Our ref: Griffith Battery Energy Storage System (SSD-85372970)

Subject: Request for Additional Information

INTERSECTION OF:
PRINCES MOTORWAY AND PICTON ROAD
CATARACT

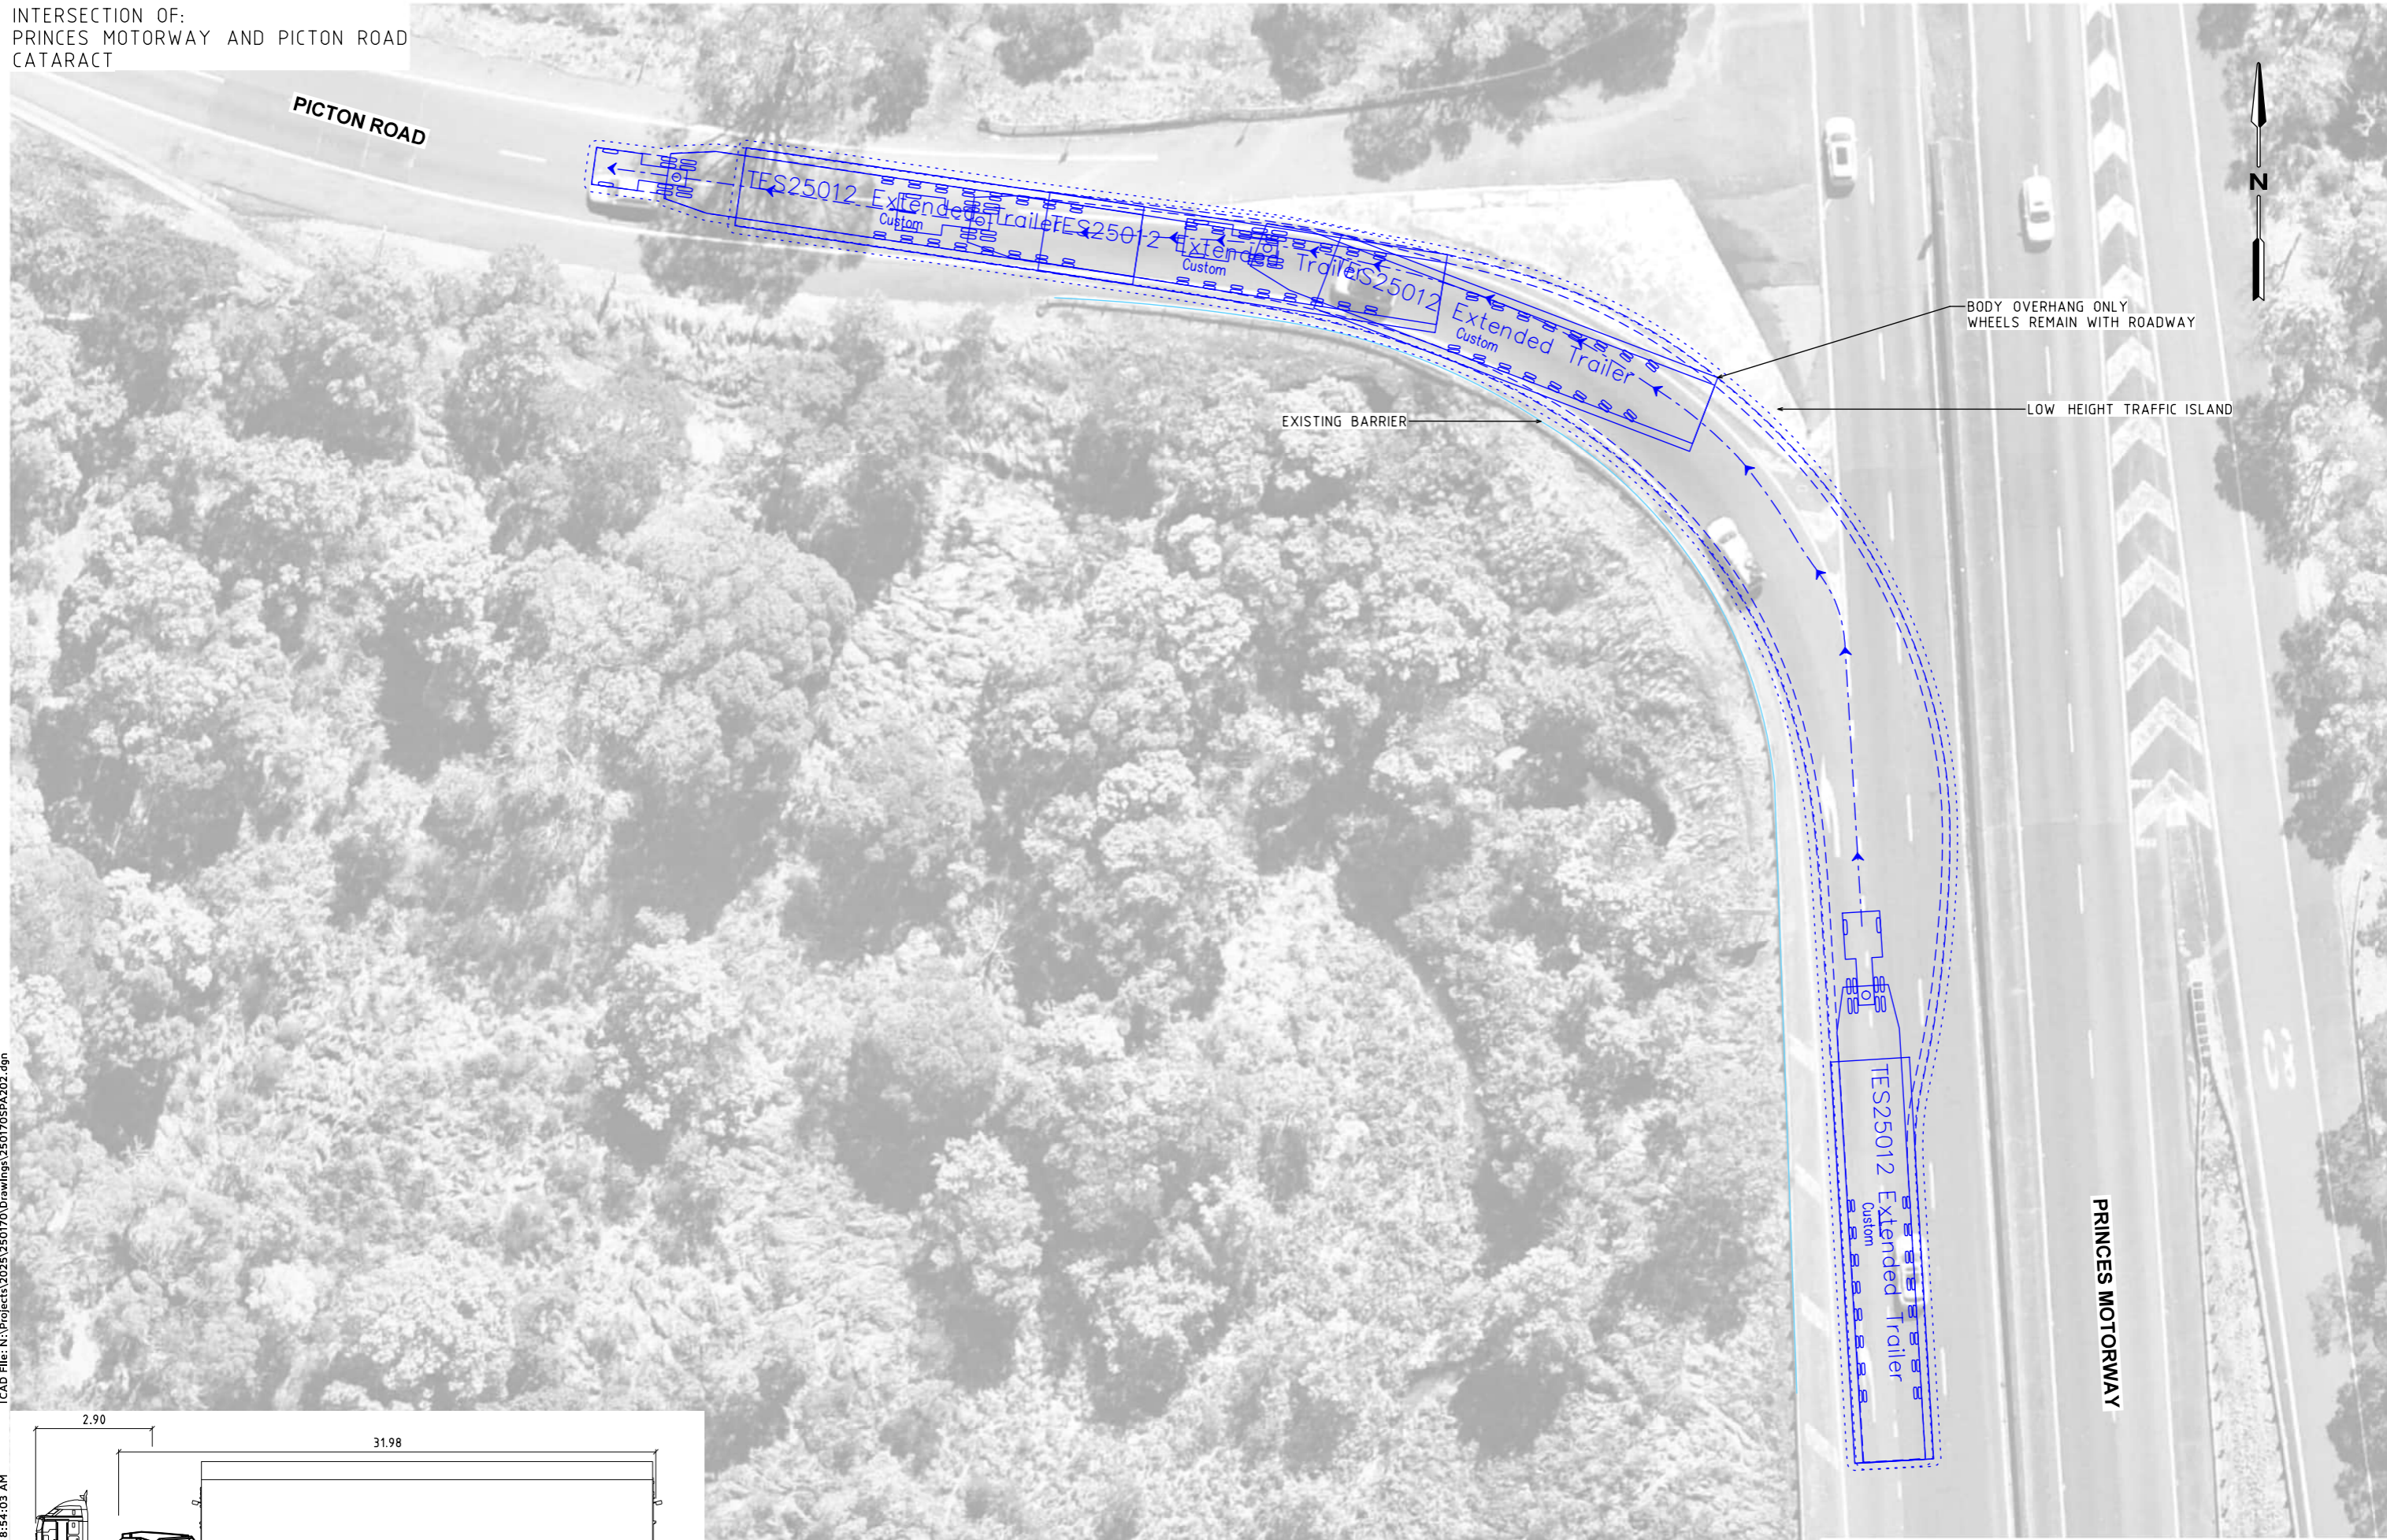
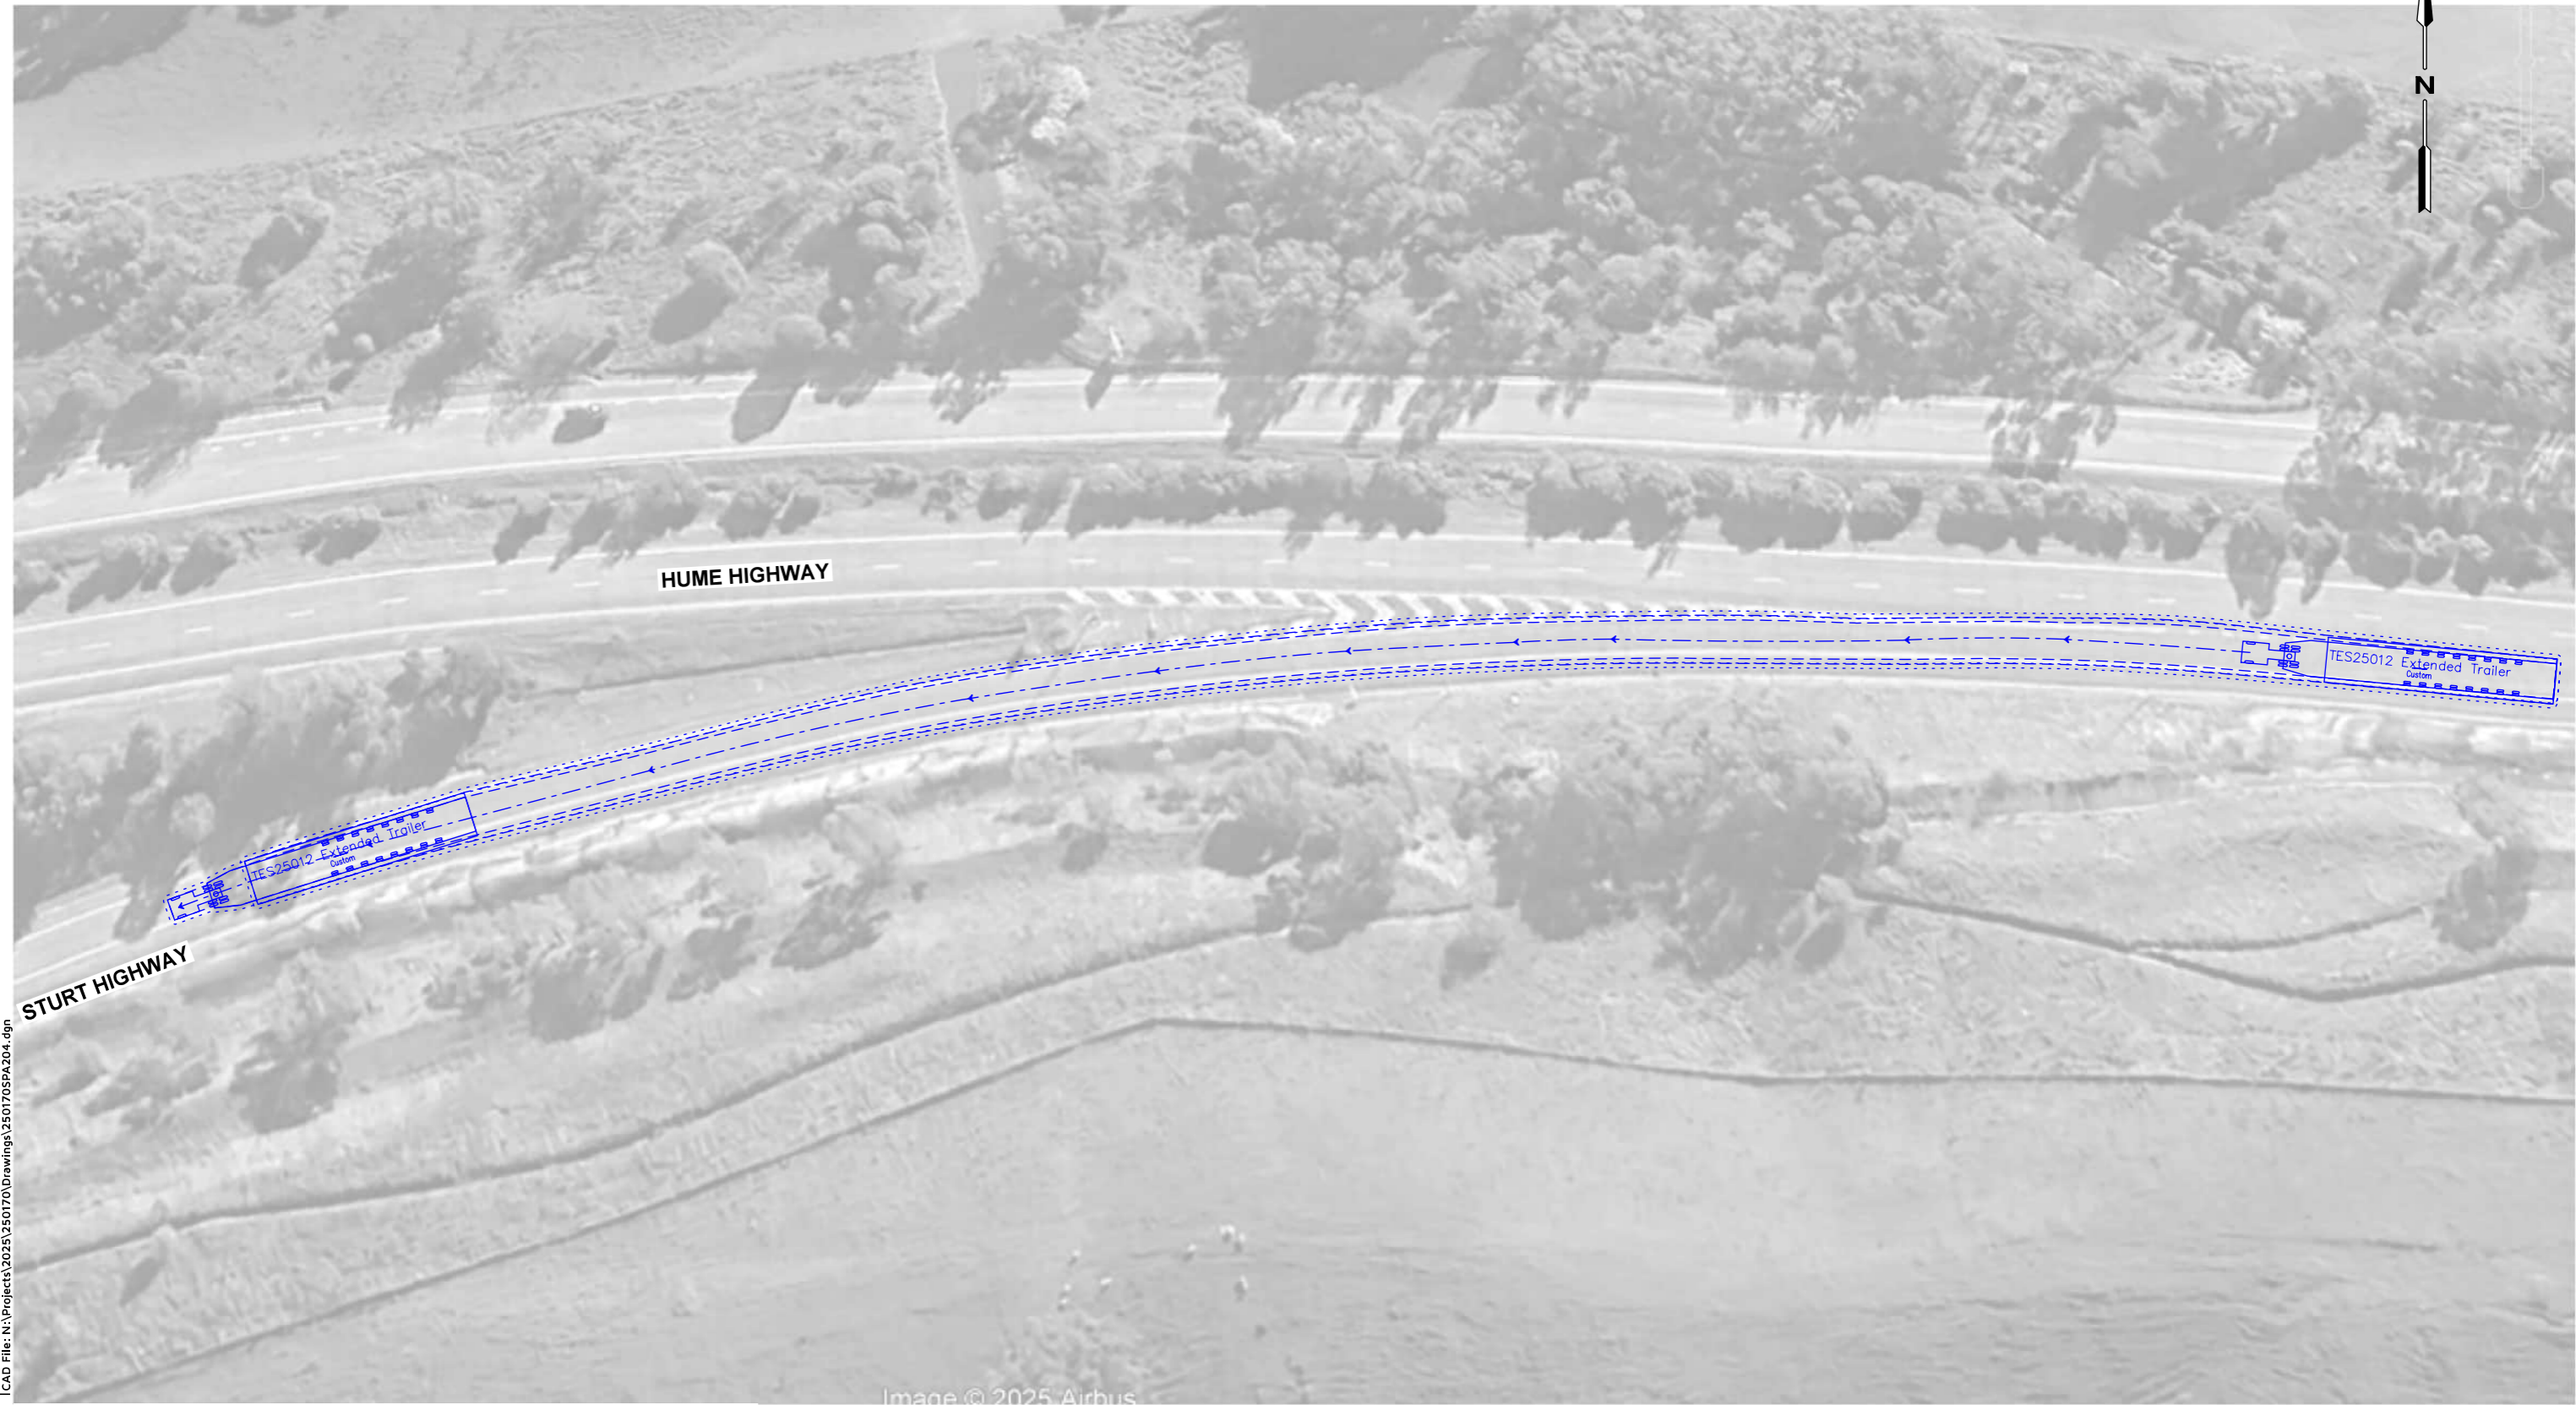
- further detail on transport and traffic matters, including:
 - o on the load capacity and dimensions (including vertical geometry) of the culverts proposed to be traversed for the heavy vehicle requiring escort and heavy vehicle haulage routes;
 - o update the swept path diagrams to identify the proposed roadworks to medians, aprons and other road structures; and
 - o clarification on the transmission line crossing Irrigation Way and on pre-construction minor works;
- further detail on the project area and site design, including on the total development footprint (in hectares), consideration of construction and equipment laydown areas for constructability, and provision of high level concept designs for the three proposed site access points; and
- provision of landowners consent for all areas with road works proposed along the haulage route.
